## **SUBMISSION AS THE LOCAL PLANNING AUTHORITY**

**1.1.** The following information is submitted in response to the examinations taken place between 3<sup>rd</sup> December 2024 and 5<sup>th</sup> December (ISH1 – 5) and the information submitted at Deadline 3 by the Applicant (National Highways) for the A46 Newark Bypass for an Order granting Development Consent. Our comments follow the Council’s Local Impact Report (REP1-035), Written Representations (REP2-051), response to ExQ1 (REP2-050) and comments on Deadline 2 submission documents (REP3-046), namely the Historic Environment and Visual Impact Assessment (REP2-020).

**1.2.** The comments made for Deadline 4 are made by Newark and Sherwood District Council in their statutory role as the Local Planning Authority (LPA) and not as landowner. Where comments are made as the landowner these are clearly defined in a separate section for the ExA to see.

Photomontage 25: Year 15 in operation (planar projection, field of view 39.6 degrees x 27 degrees, to be viewed at A3)

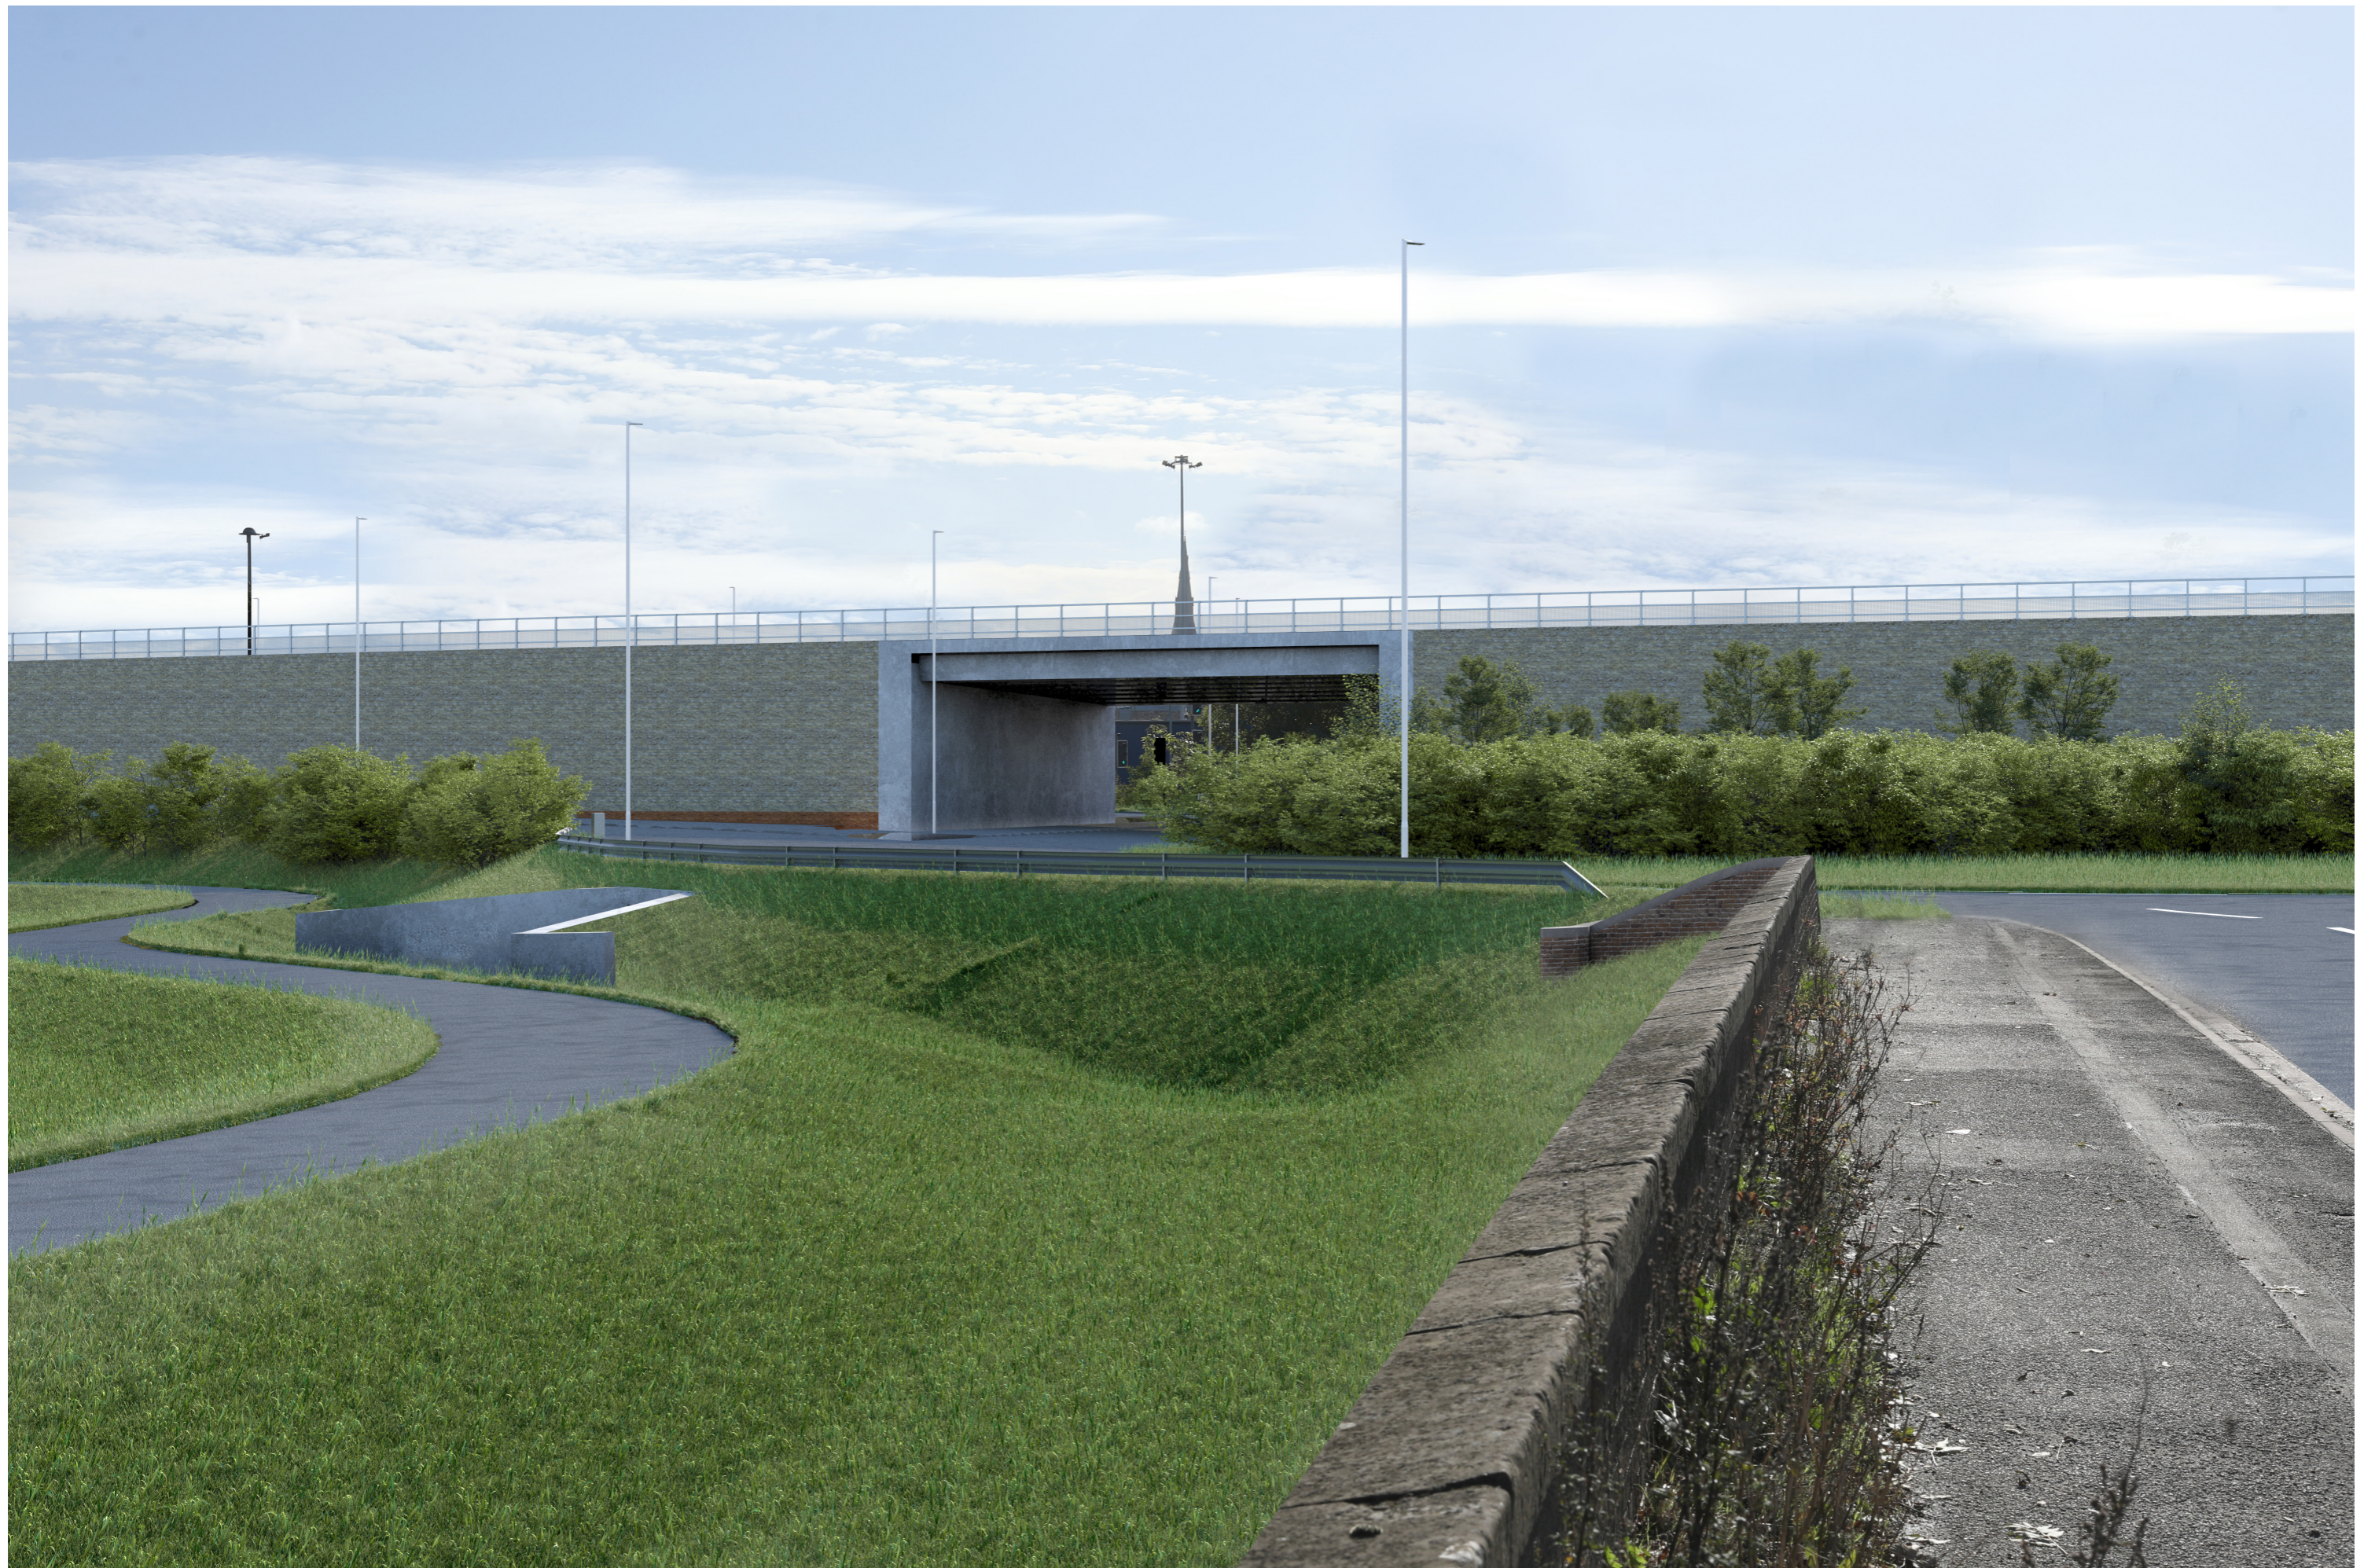
create an elevated flyover would see the landscape dominated by it without sufficient landscape mitigation as a result. (REP2-020) VP25 currently has a framed view towards the junction with vegetation on either side. At Year 1 (VP25) the vegetation has been removed and at year 15 there is not a lot of difference. With reference to BNG and the direct reference to NCA46 (National Landscape Character) and Section 4.2 which makes direct reference to boundary features within this landscape area and in particular wet willow boundary features. The existing baseline shows the framing of the approach and the character of moving along the A616 is fairly consistent in that there is a mature boundary treatment for some distance on a straight road with long distant views. However where there has been a loss of that vegetation the Council would like to see some confidence that that vegetation can reestablish again overtime and we feel that looking at that baseline position it seems a rational position.
